Martin Nugent
01254 828060
D3/12/0528

Drafted 21 August 2012

**Planning Application, Ribble Valley District
3/12/0578 Outdoor Activity Centre, Whalley Road, Read**

drg.no. 11/26 PL 01 rev C

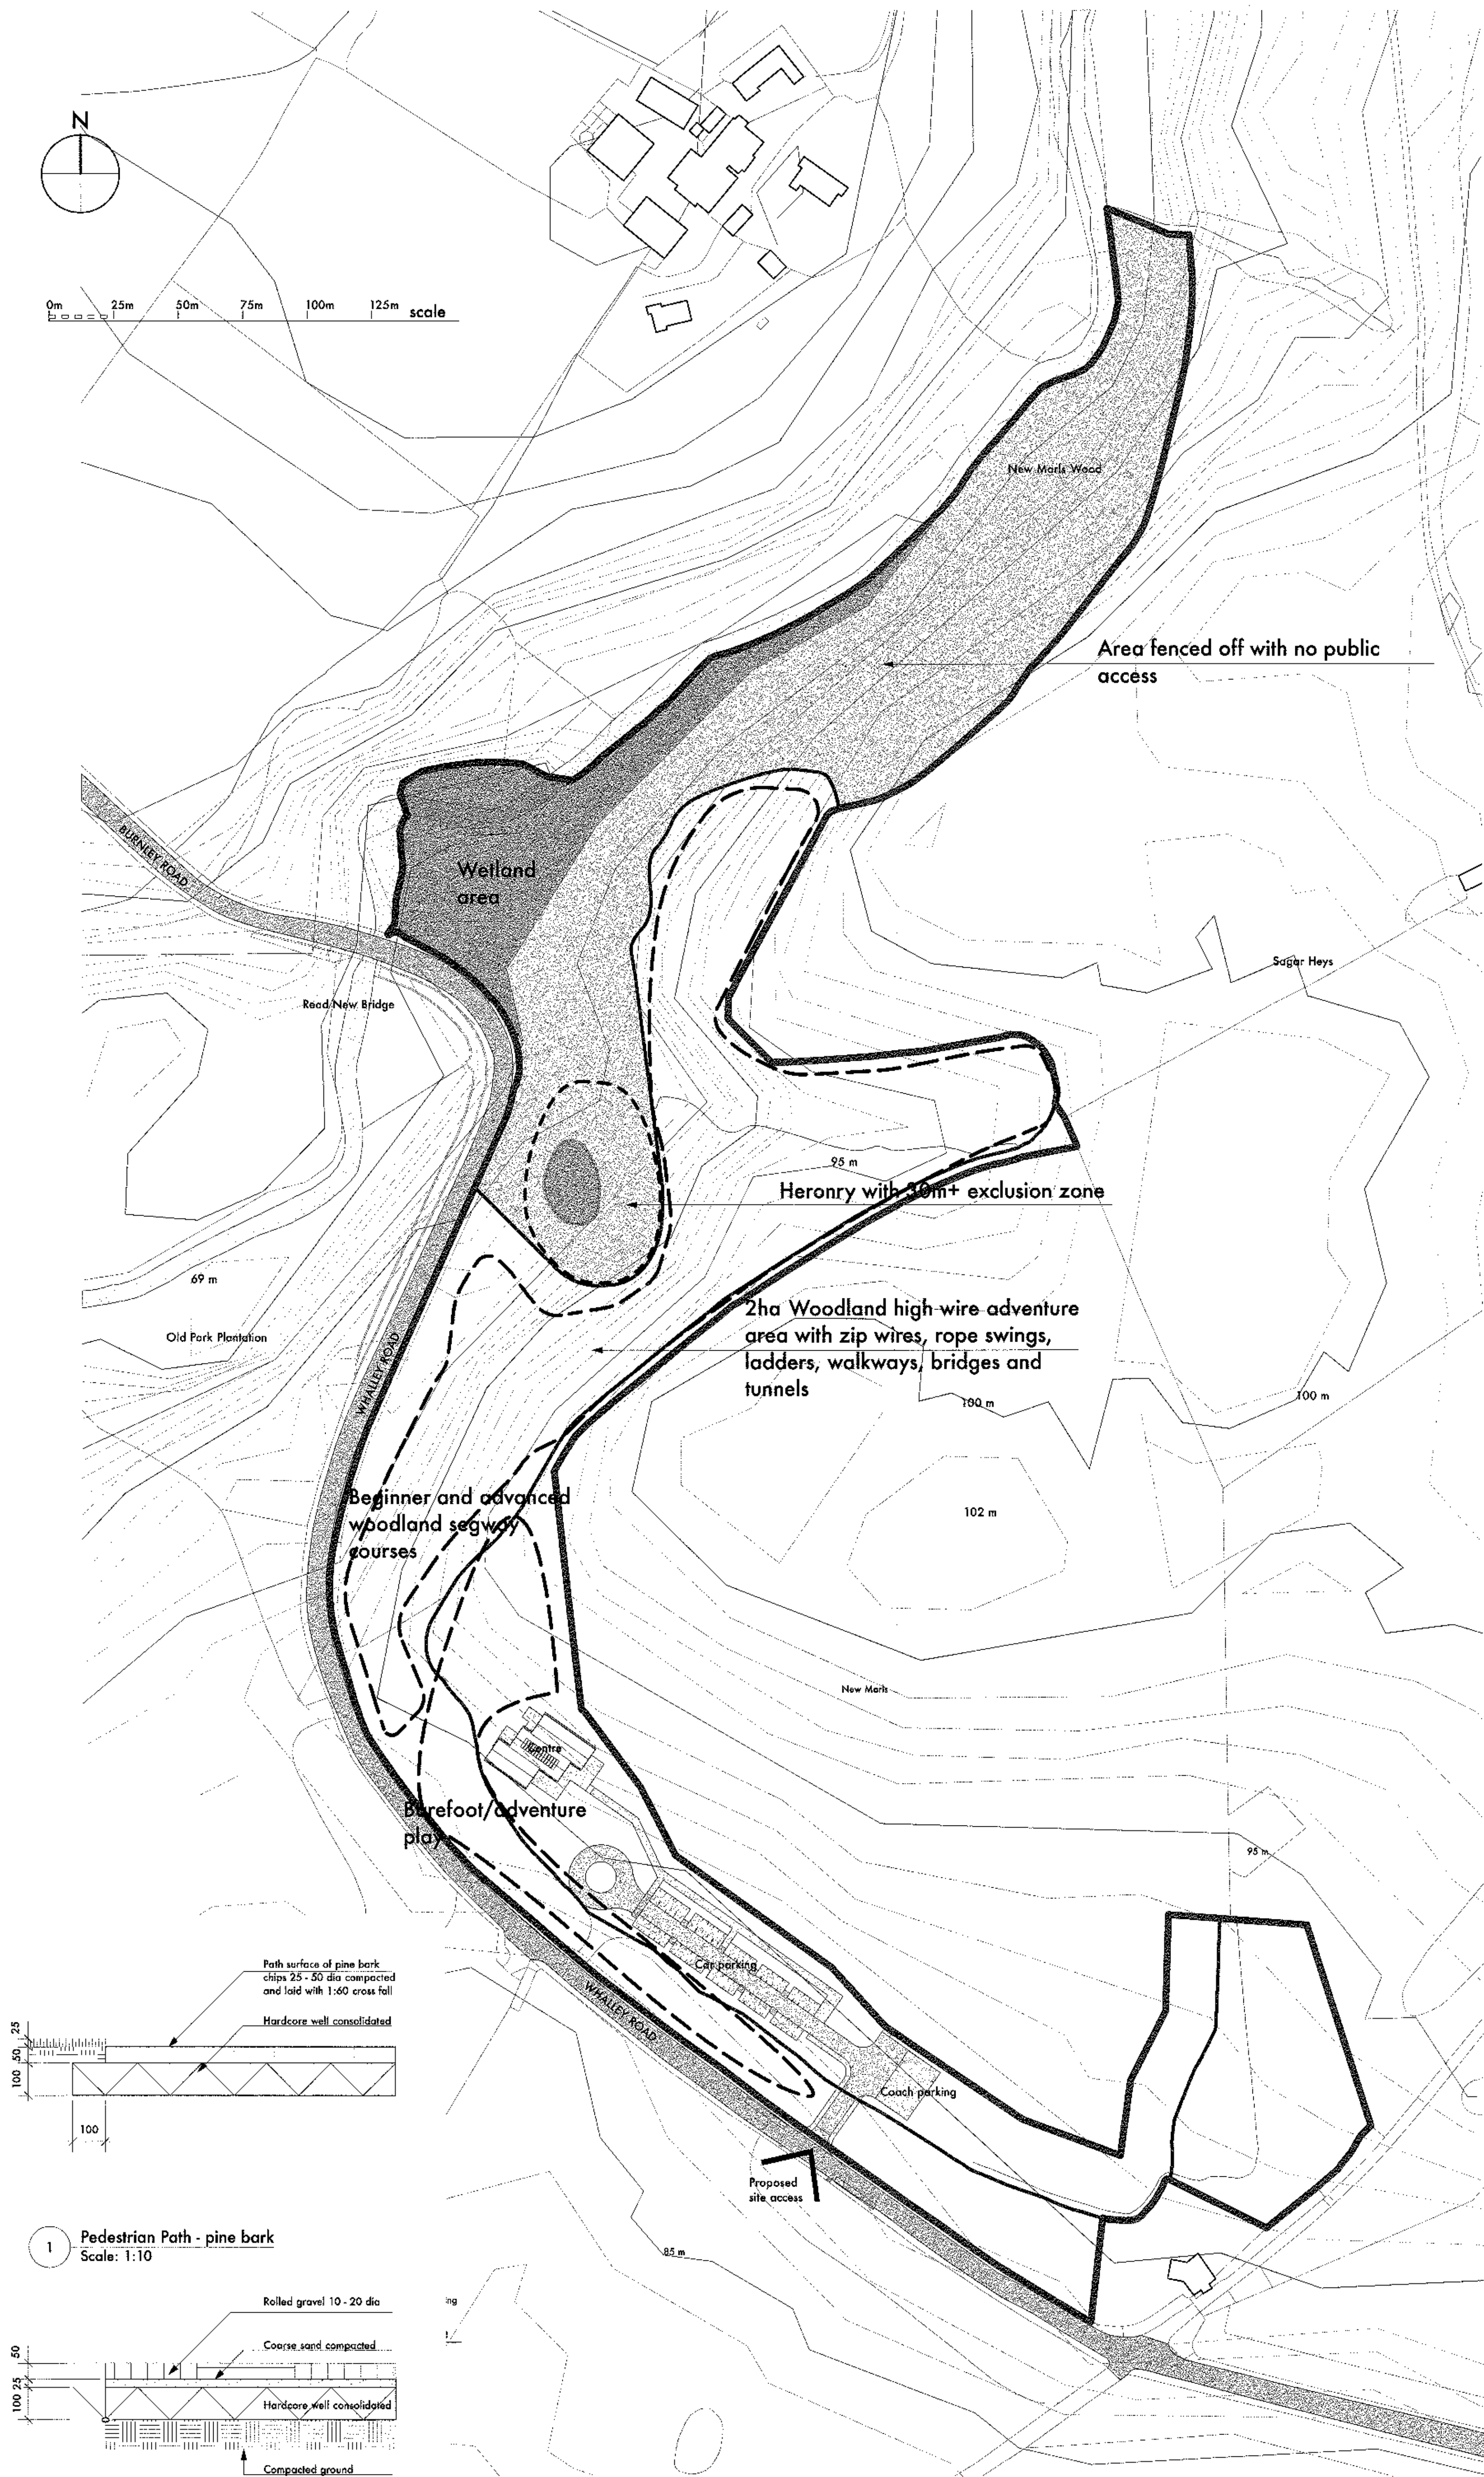
As indicated on plan, the existing field gate access to the west of the proposed access is to be permanently closed and planting reinstated. This requirement will be supplemented by a formal Highway Condition.

The site plans indicate that the main vehicular access from Whalley Road is not to be gated. I have every confidence that the site security has been considered in great detail, but would highlight that this leaves open the opportunity for the site to be accessed by unauthorised groups or individuals.

I would ask that consideration is given to omitting the rumble strip shown on the entrance to site. This will be the focus for all vehicular movements and does not serve a specific speed reduction or other safety function. Given the maintenance required on rumble strips and the proximity of on-site facilities for buses and coaches, I would recommend that this feature is removed at this location.

The provision of linked footway provisions. There is an existing footway to the south side of Whalley Road and provisions should be made for drop kerb links to and across the proposed access. The extent of any new lengths of footway would be a matter for more detailed discussion.

Provide drop kerbs from the south side of Whalley Road to both sides of the main access and across this access. This will allow pedestrians to reach the site from a continuous footway link. New footways must also be provided to both sides of the main entrance.

AMENDED PLANS RECEIVED
DATE 19/10/12

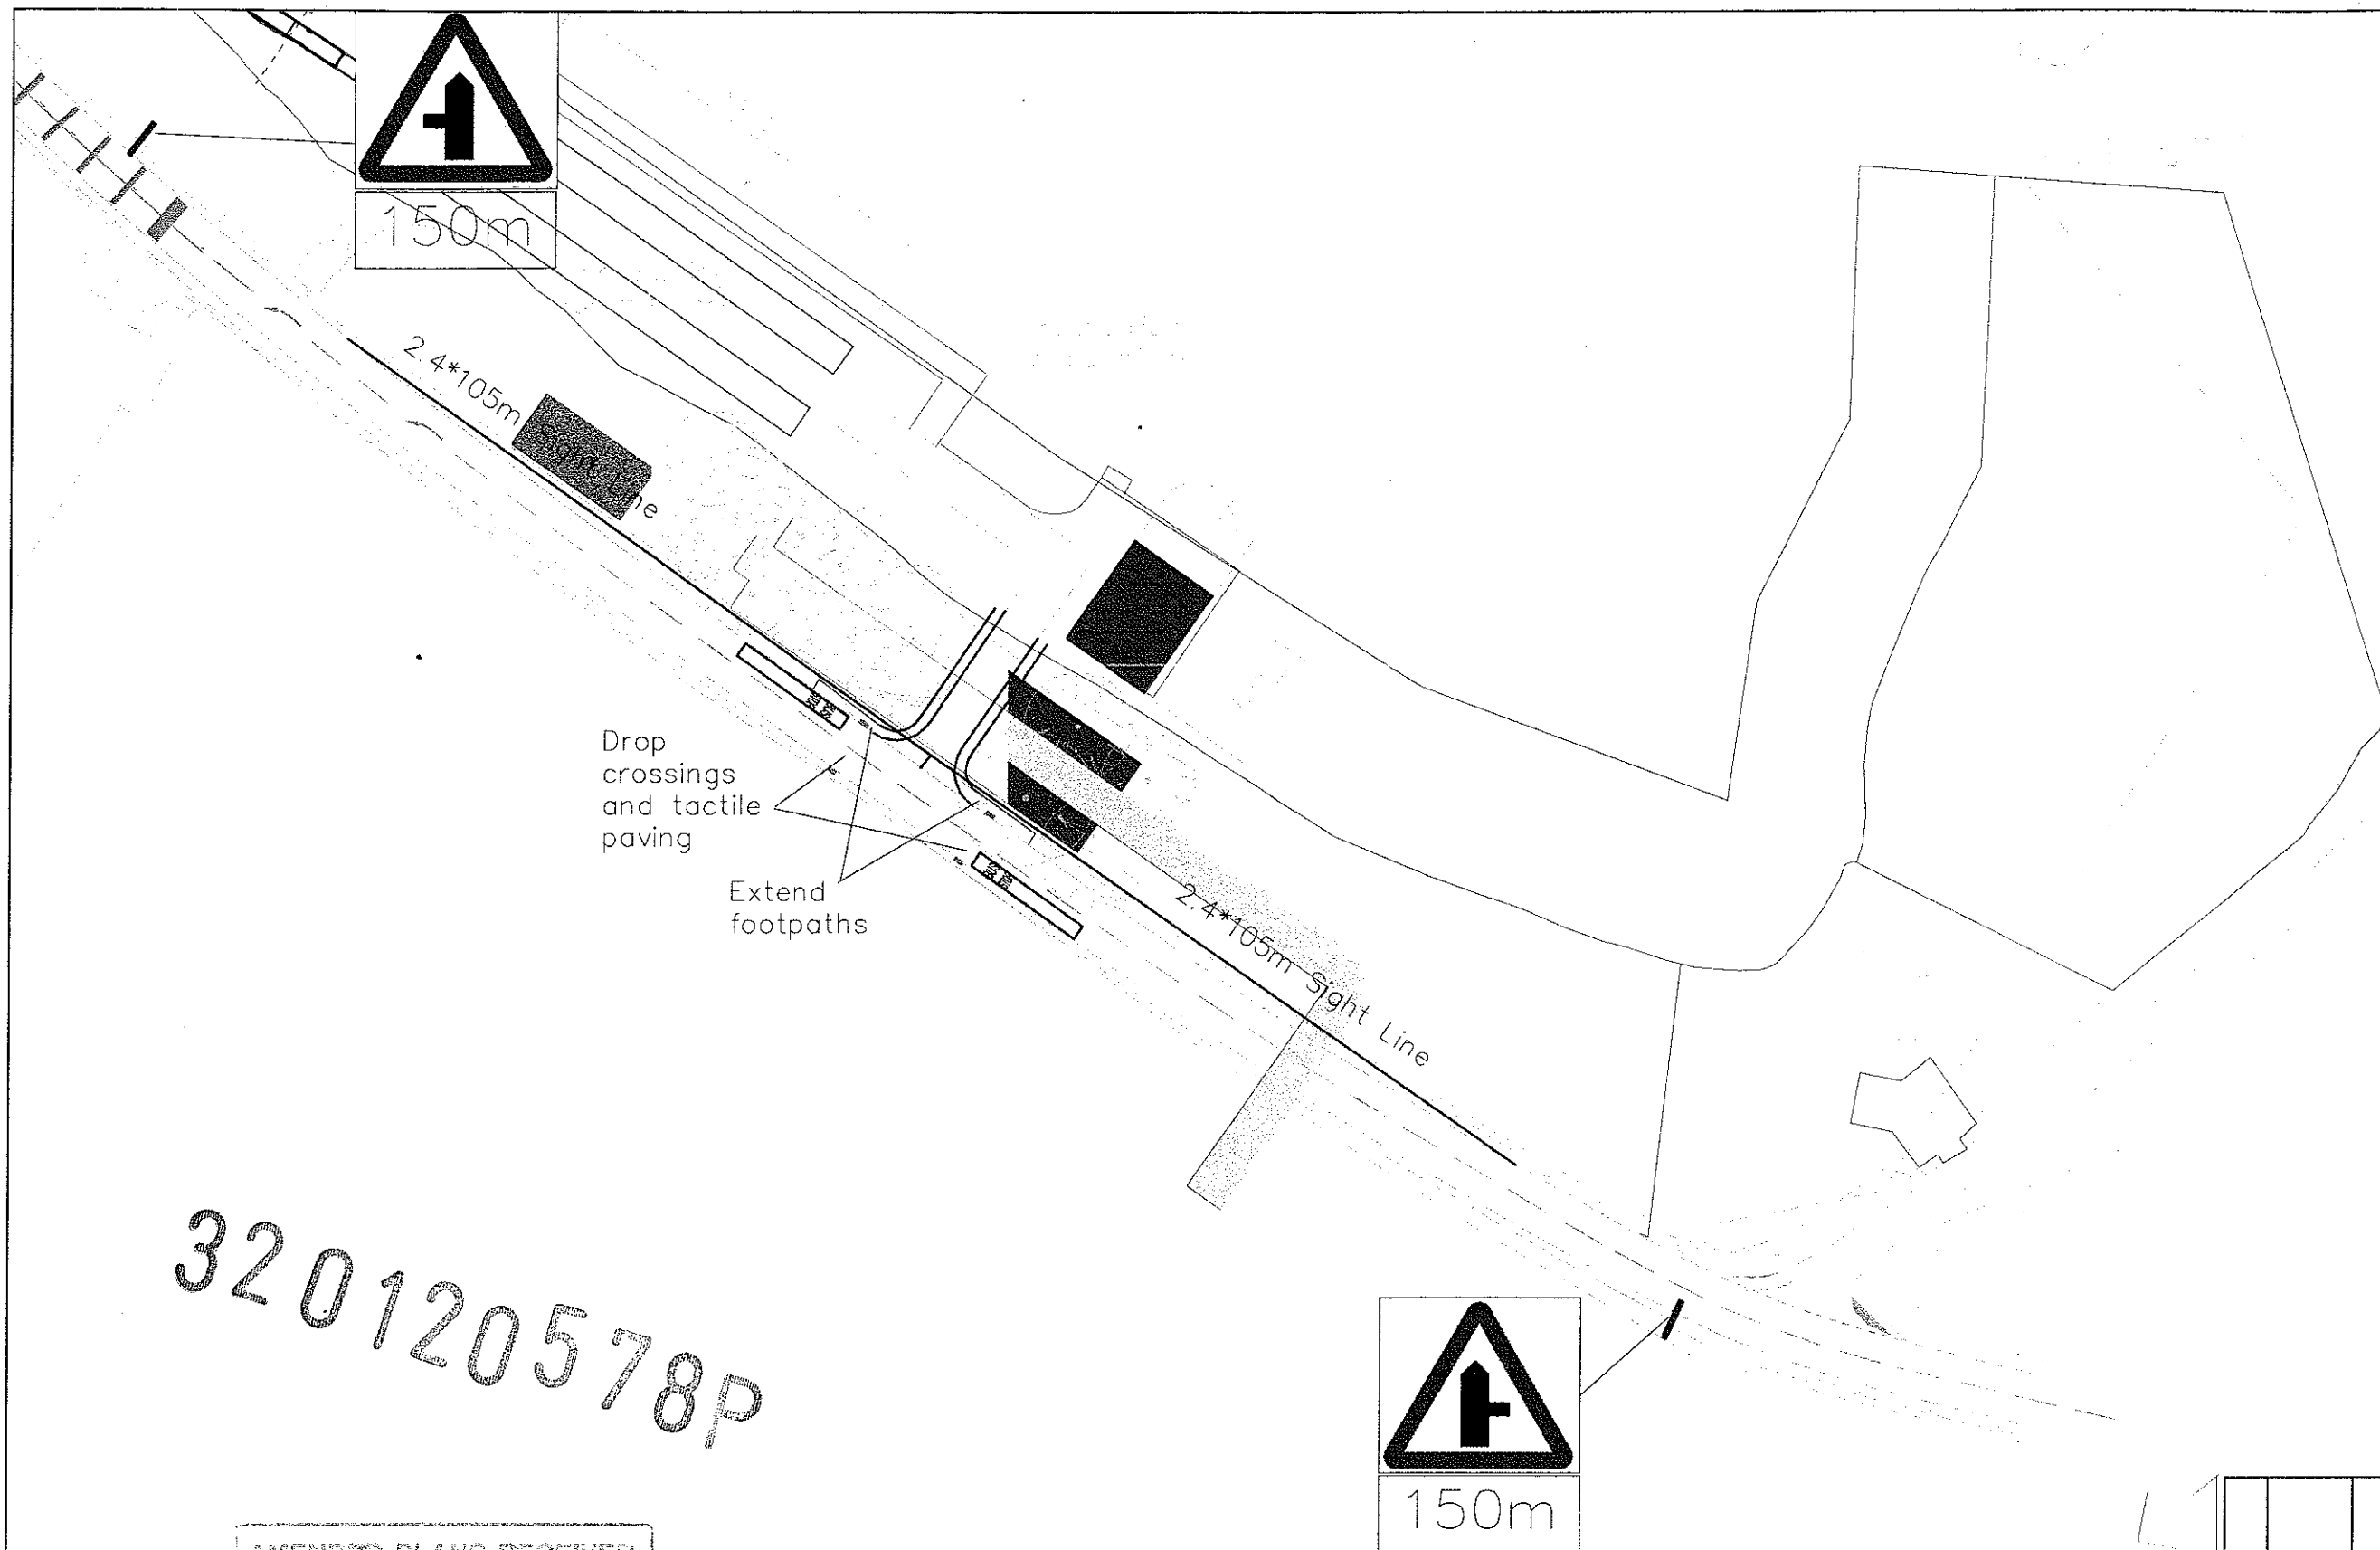
The calculation for visibility splays contained in the Transport Statement accompanying the application identify a range of 105m to 120m as being acceptable for the measured vehicle speeds on Whalley Road. I am content that this is accurate and a reasonable basis on which to proceed.

Working with the lower figure of 105m by 2.4m, the impact of construction on adjacent planting and established hedgerows is minimised. As I have no objection to the introduction of the splays achieved using this figure on this section of Whalley Road, the retention of the planting is an additional benefit.

The proposed access point does not appear to require the removal of any mature trees, but there will be requirements to raise the crown on some specific trees and to alter the line of hedgerows that fall within the visibility splay.
